CIMARRON HILLS - PHASE 2
SANITARY AND WATER SERVICE PLANS
WATER SERVICE PLAN

CIMARRON HILLS DEVELOPMENT PLAN

L-701

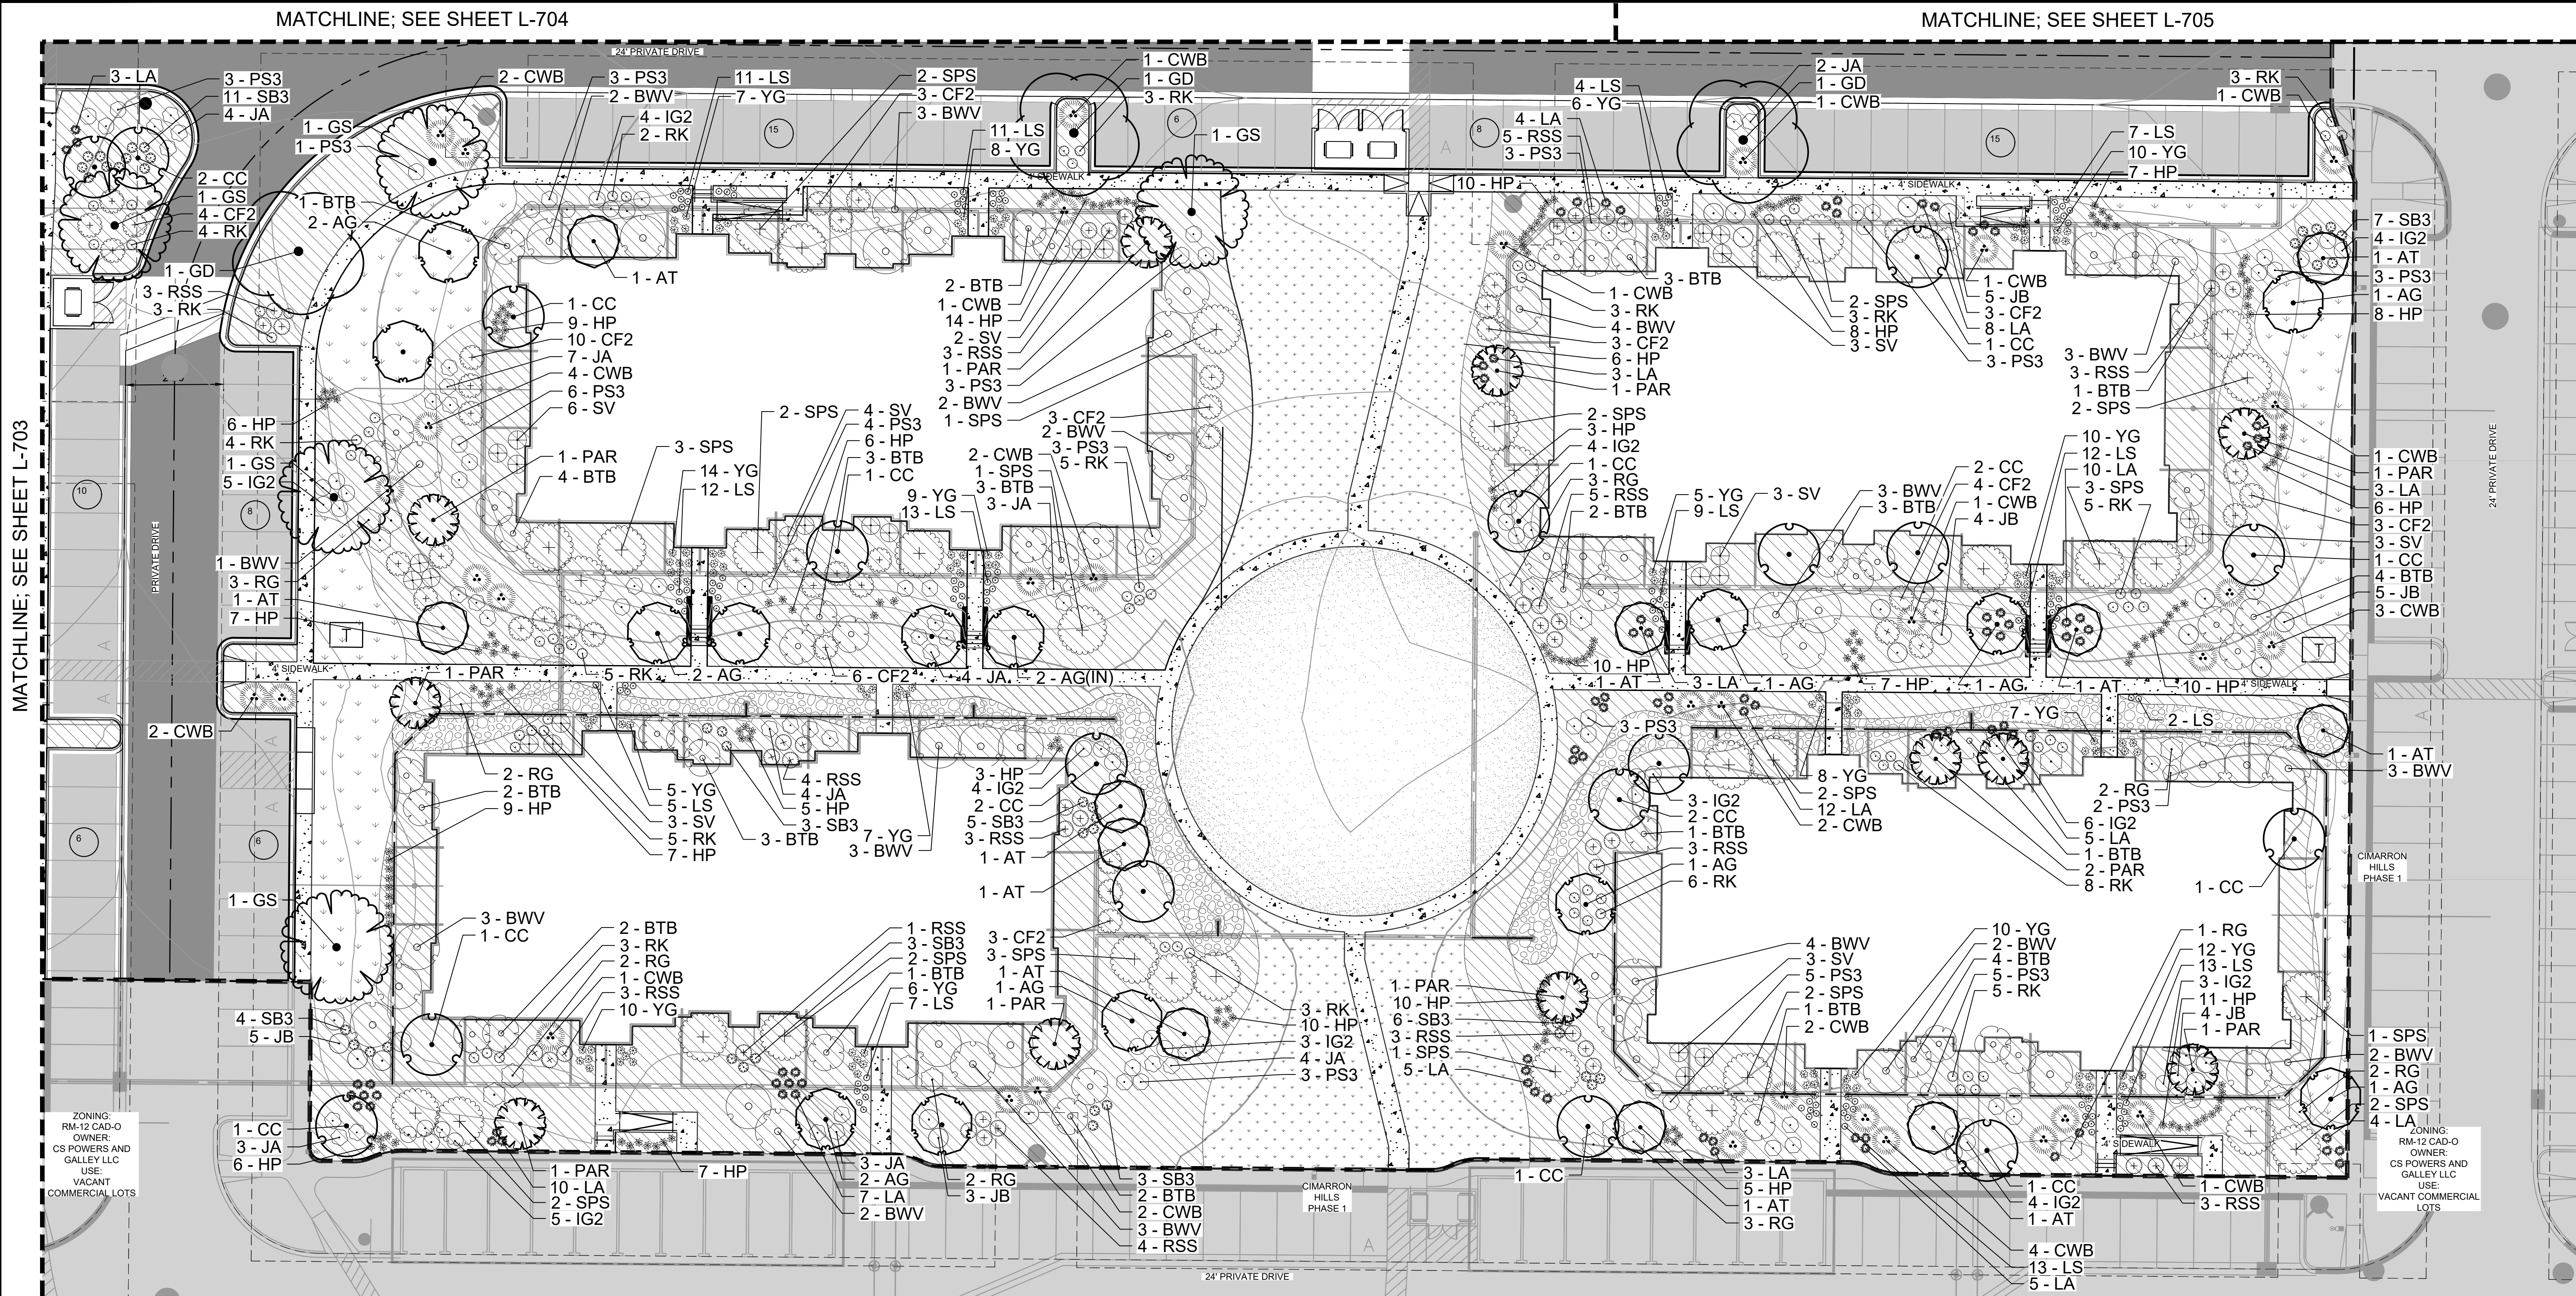
Is this the correct name for this project?

Add PCD File Number

This appears to be a City of Colorado Springs standard block.

Remove City approval block

SOLACE APARTMENTS, FILING NO. 2, LOT 1
 SITE DEVELOPMENT PLAN
 LANDSCAPE NOTES

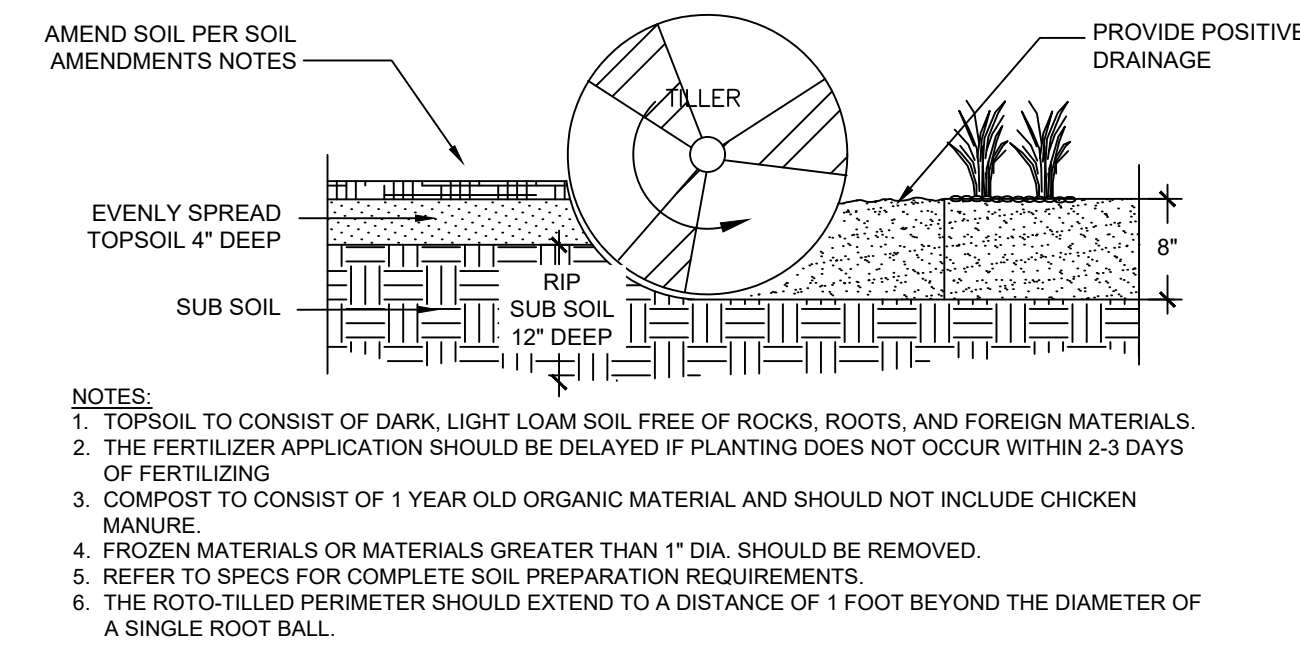
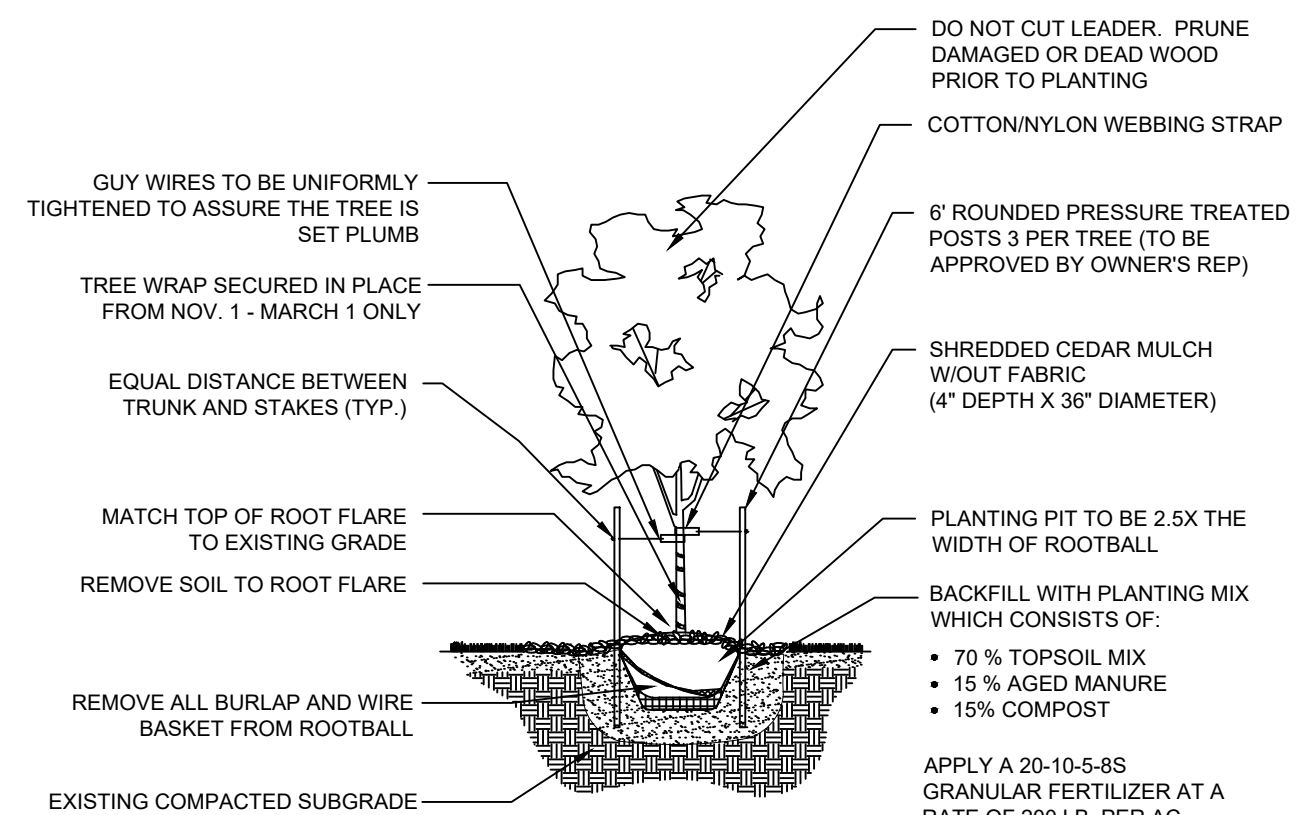
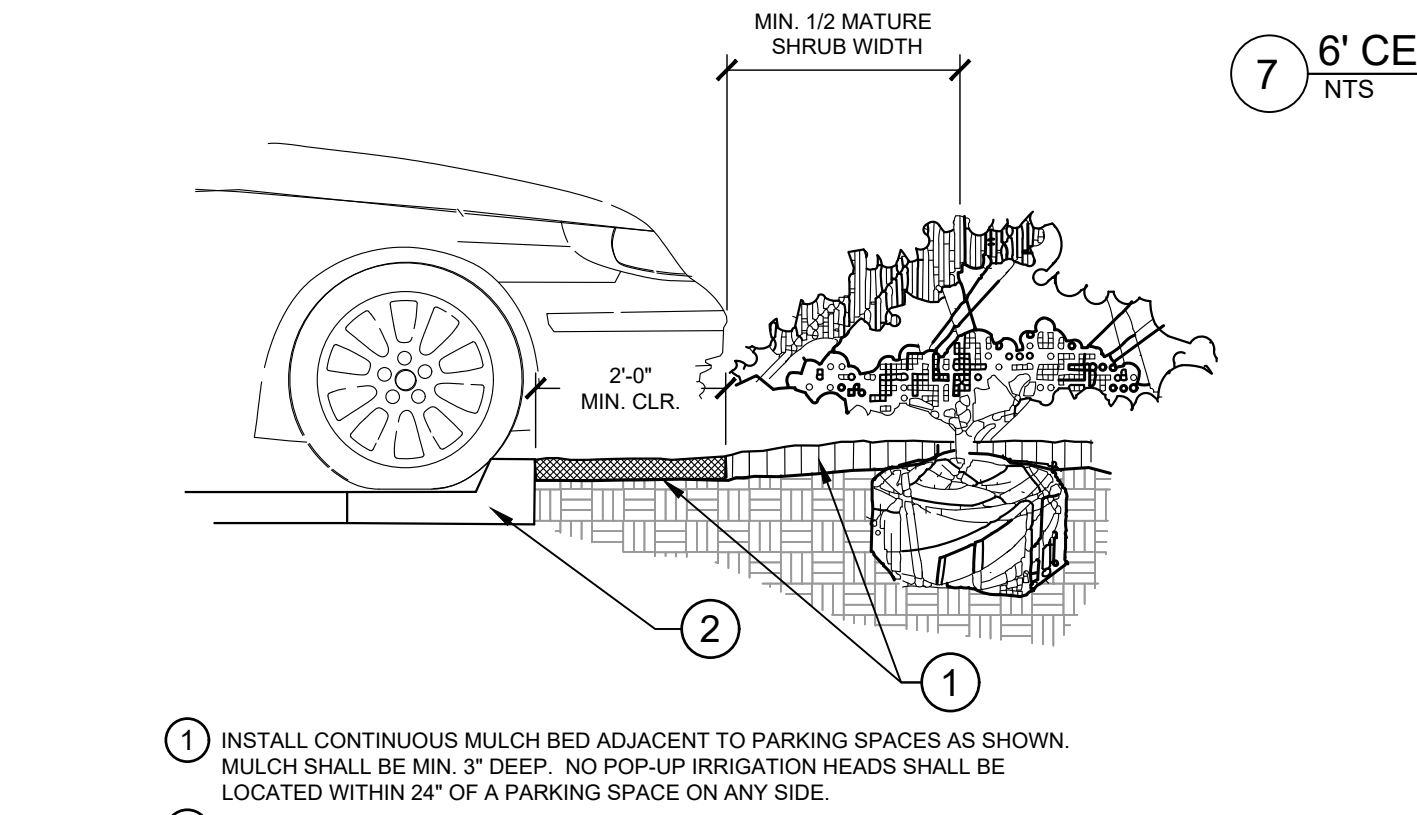
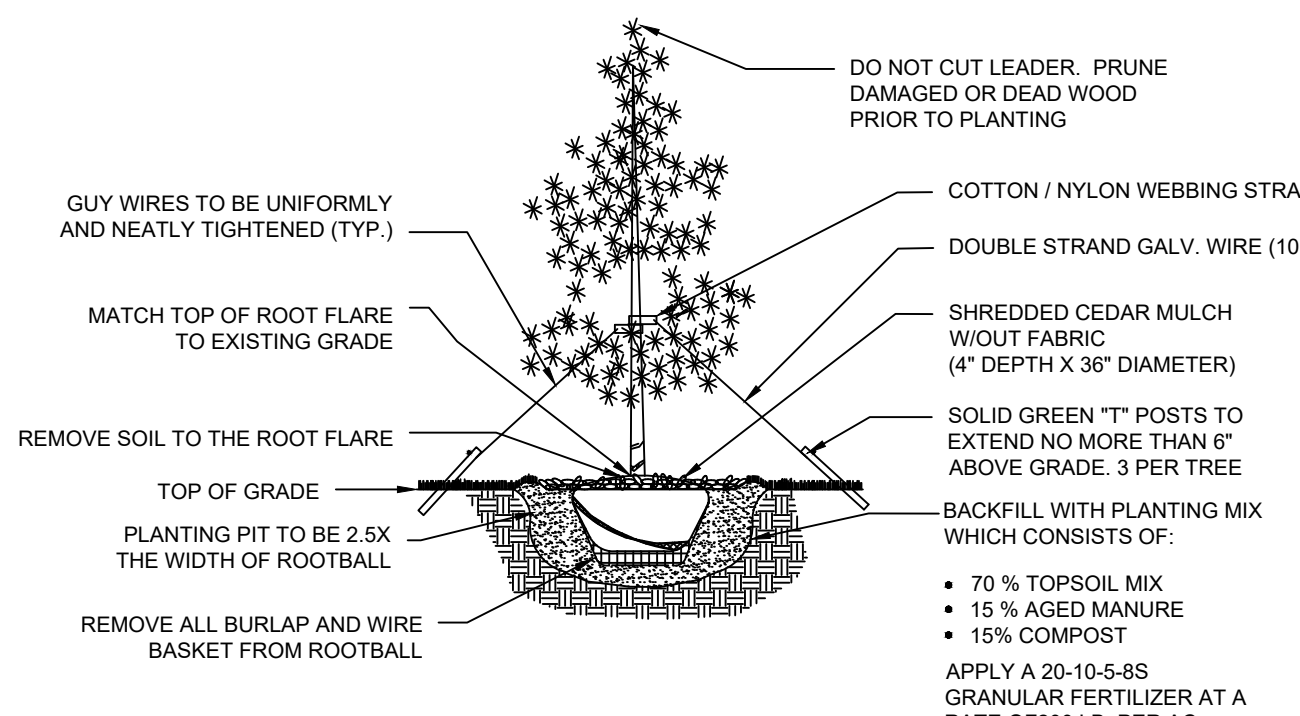
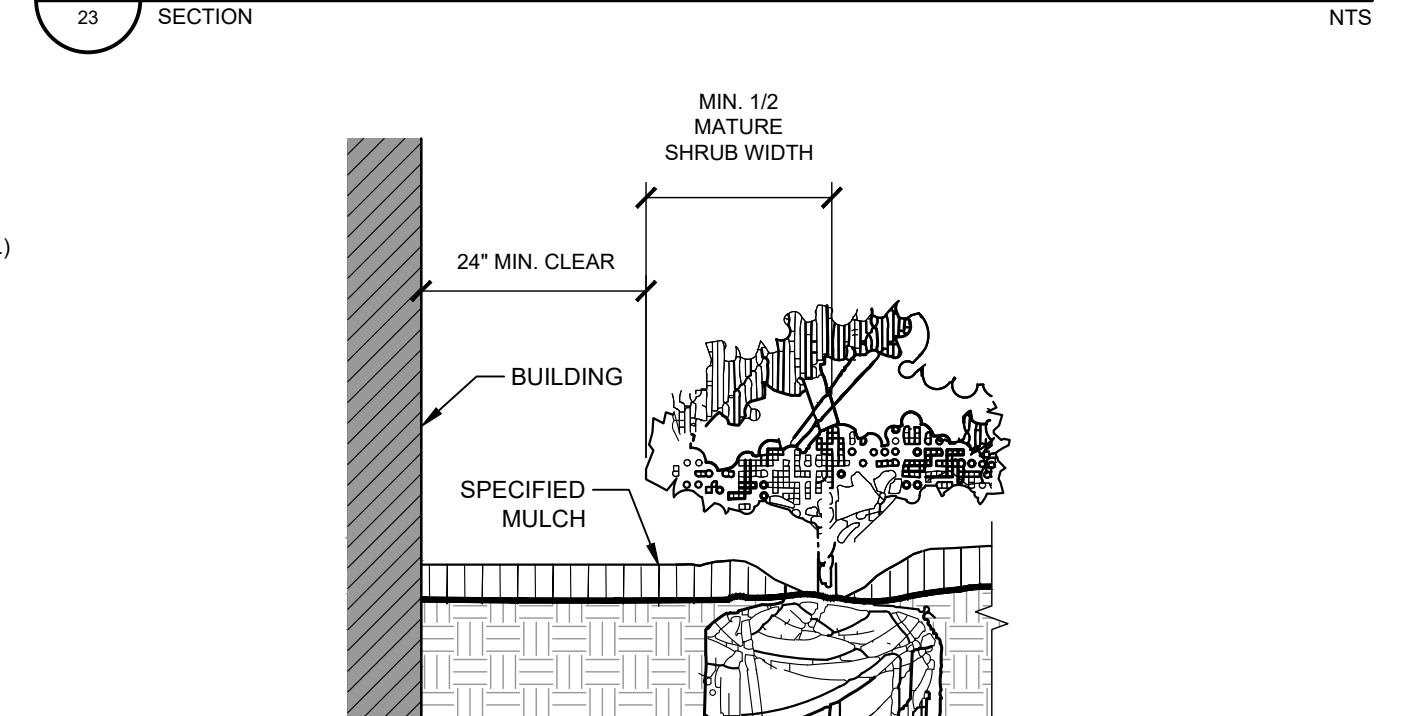
The Code requires that 1/3 of the trees shall be evergreen

Recommend adding opaque screening to help screen residential uses from adjacent nonresidential uses. Not required since road buffer to the north, but still recommended

Please ensure required buffers are not included in this calculation

Please see below excerpt from the Code. I am not seeing where this has been provided.

(5) Required Parking Lot Screening. Parking lots shall be screened from view from adjacent roads and properties with differing land uses. The minimum height of the screening shall be 3 feet and may be accomplished by using berms and plantings. A minimum of 1/3 of the road frontage or common lot, parcel, or tract boundary, not counting intersecting driveways, shall be provided with the required screening. The maximum spacing of plants to achieve an acceptable screen and the maximum acceptable grades for screening areas, such as grass berms and plantings beds, should be consistent with the Landscape and Water Conservation Manual.
